WEST SUSSEX COUNTY COUNCIL CONSULTATION

TO:	Arun District Council Ross Leal
FROM:	Debbie Farrell WSCC County Highways
DATE:	14/3/18
SUBJECT:	FG/33/18/PL Demolition of polytunnels, use of land for Class B8 container self-storage & the siting of 42 No. single-stacked storage containers, an office/toilet portacabin, new fencing, gates, CCTV, lighting & alterations to the entrance. Land at former McIntyre Nursery, Littlehampton Road, Ferring, BN12 6PG
DATE OF SITE VISIT:	
RECOMMENDATION:	☐ Advice ☐ Objection ☐ Modification ☒ No Objection ☒ More Information ☐ Refusal
S106 CONTRIBUTION TOTAL:	TBC

TITLE PROPOSED SITE & BLOCK PLAN	DWG NO 5285-2	REV C
--	-------------------------	-----------------

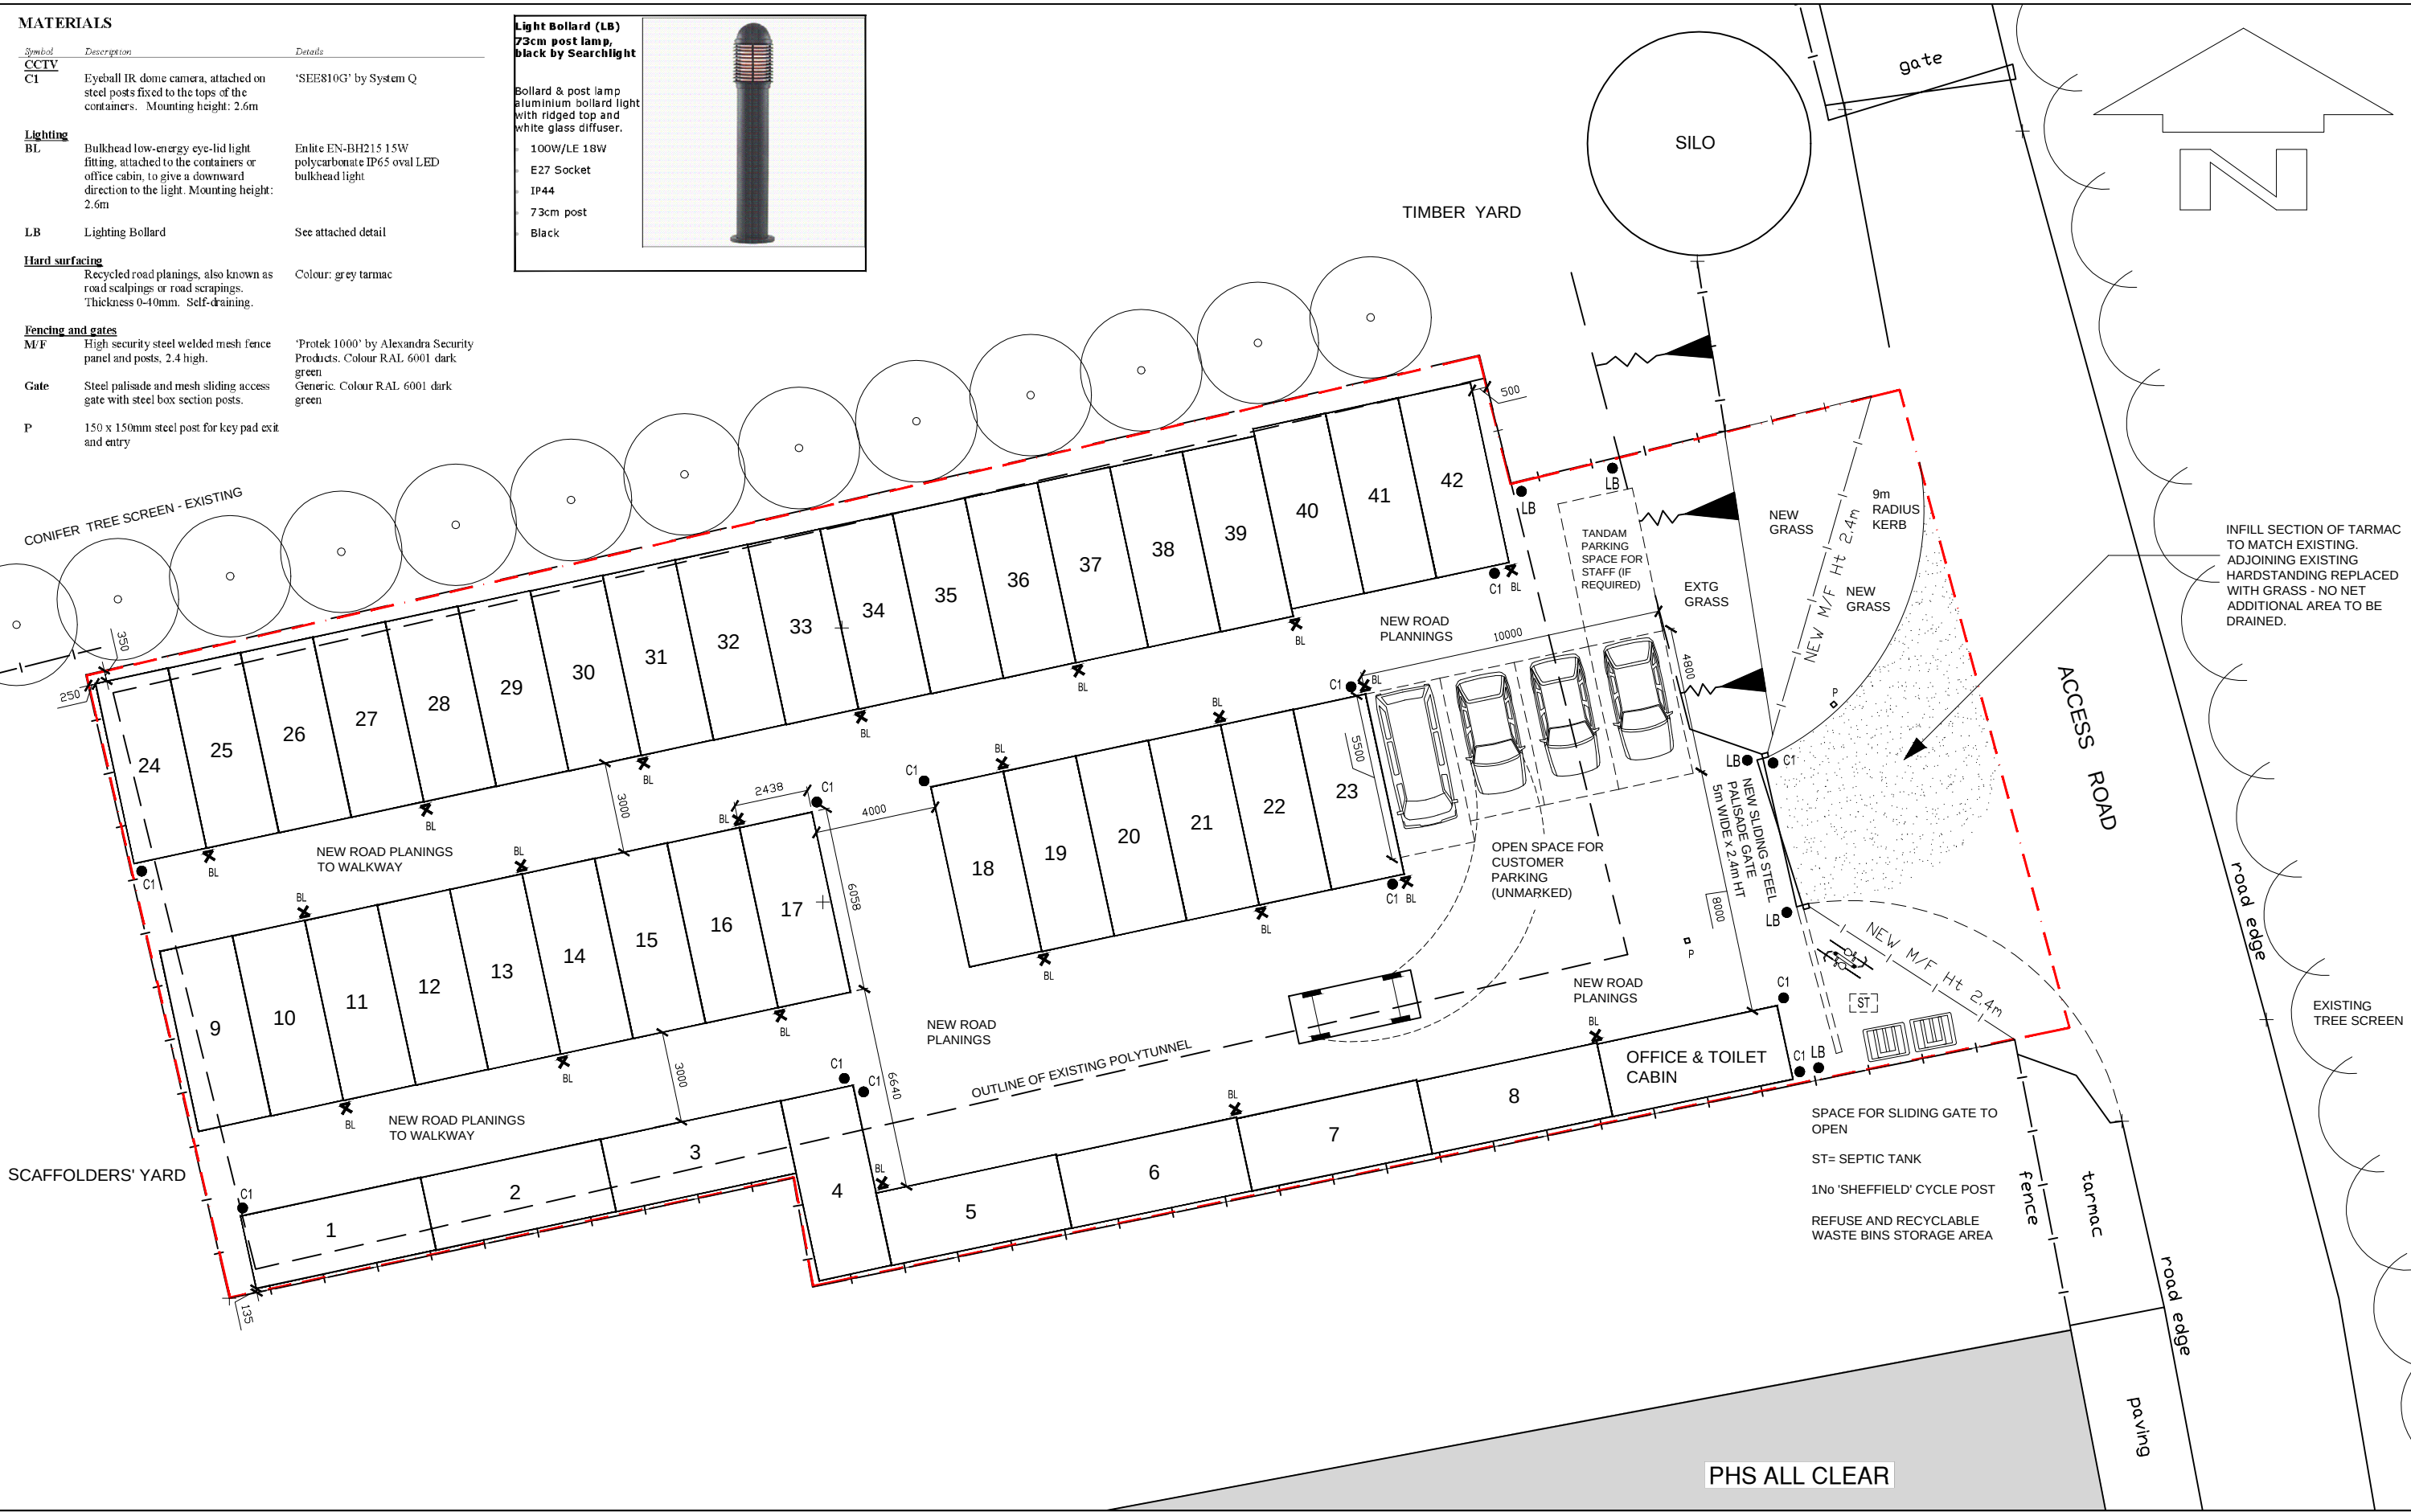
No information has been provided on how the containers will be delivered/removed from the site ie on what sort of vehicle. It is advised that

the applicant consider this to ensure there is sufficient room for large vehicles to turn into the site (from the public highway) and exit safely without impacting on the public highway. Can the applicant please provide details of how the containers will be delivered and a plan showing swept paths of the delivery vehicle manoeuvring into and out of the access with the A259. Consideration of how a large vehicle will manoeuvre within the site in order to re-enter the site in a forward gear is also required.
